## BHS Written Representation on Mynydd y Gwynt Wind Farm.

To move on to the Design and Access Statement, MyG-AD-11.

Figure 8.10b

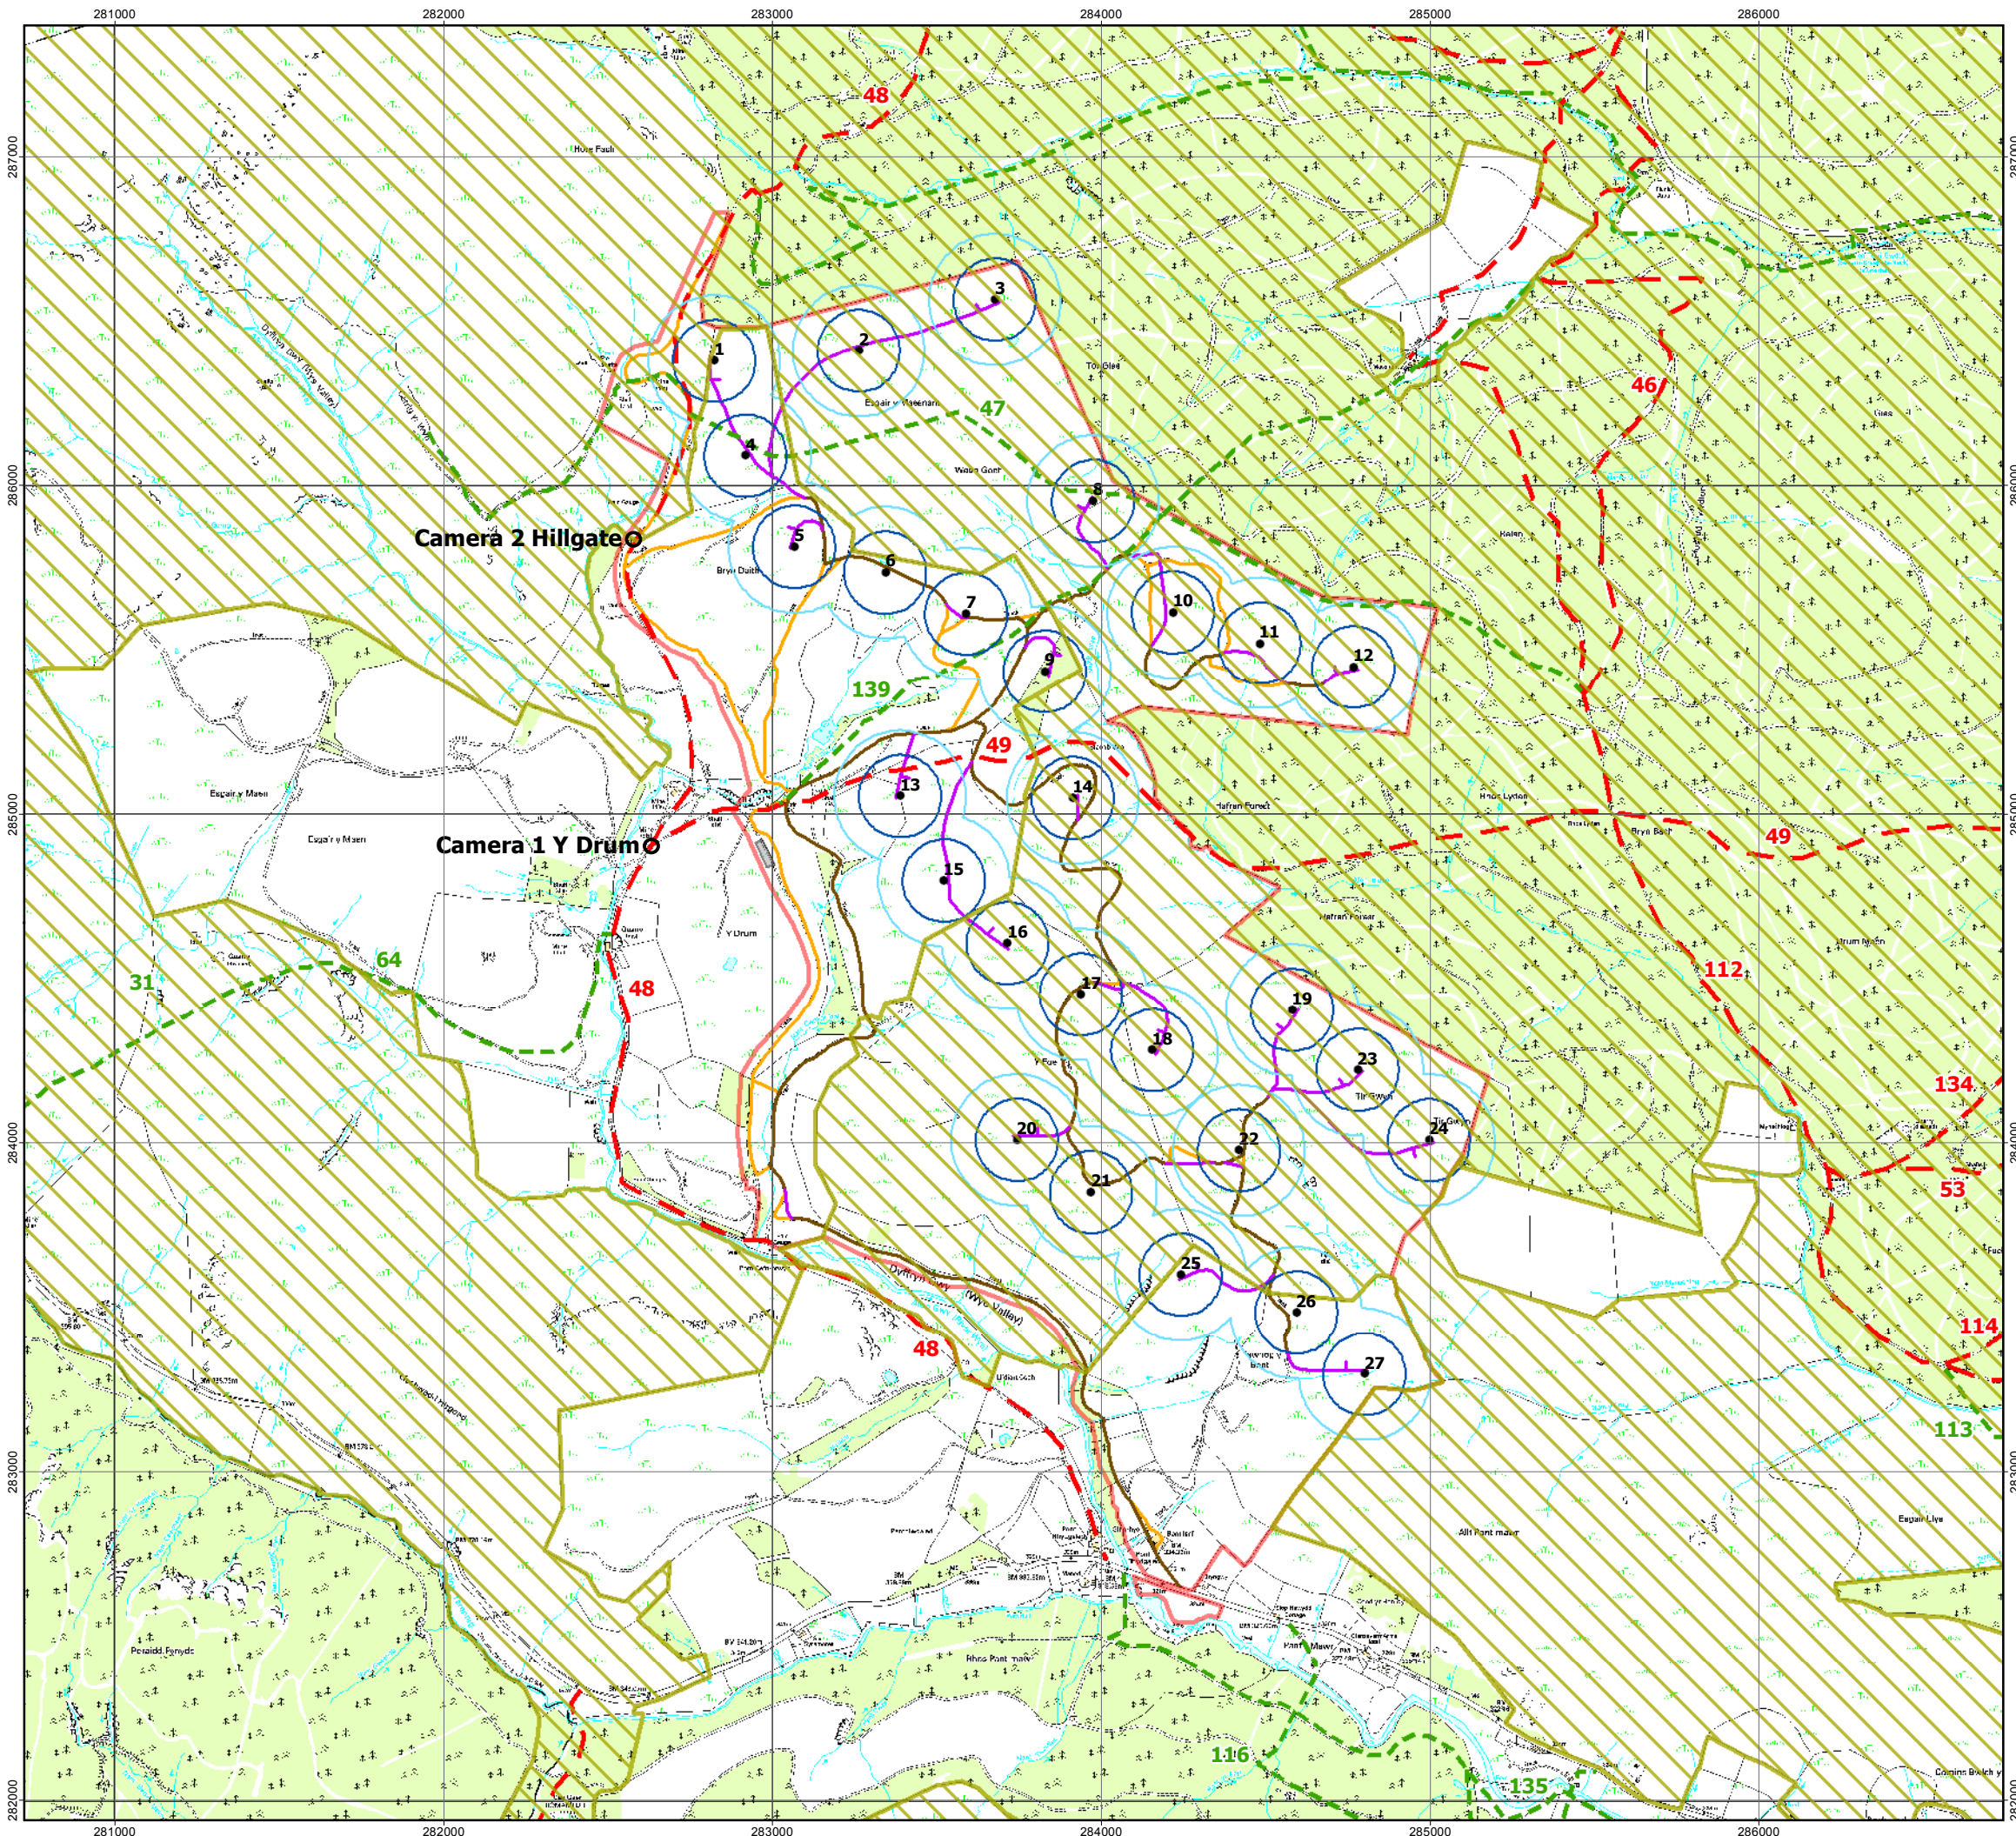
The current proposed position of T13 within 125m and T14 within 200m of BW49 would be detrimental to equestrian use of this route. T9 is well within the current BHS recommended separation distance and within the 256m separation offered by the alternative route at Pentre

Tump and rejected by Inspector Nixon. Similarly T1 within 125m and T4 within 200m would deter use of BW 48 affecting users from both the south and from the Hafren Forest. The RoW Buffer Map MyG Fig8 10b is therefore no such thing, as buffers, whether BHS recommended or TAN 8 advice, are ignored for BWs and FPs alike.
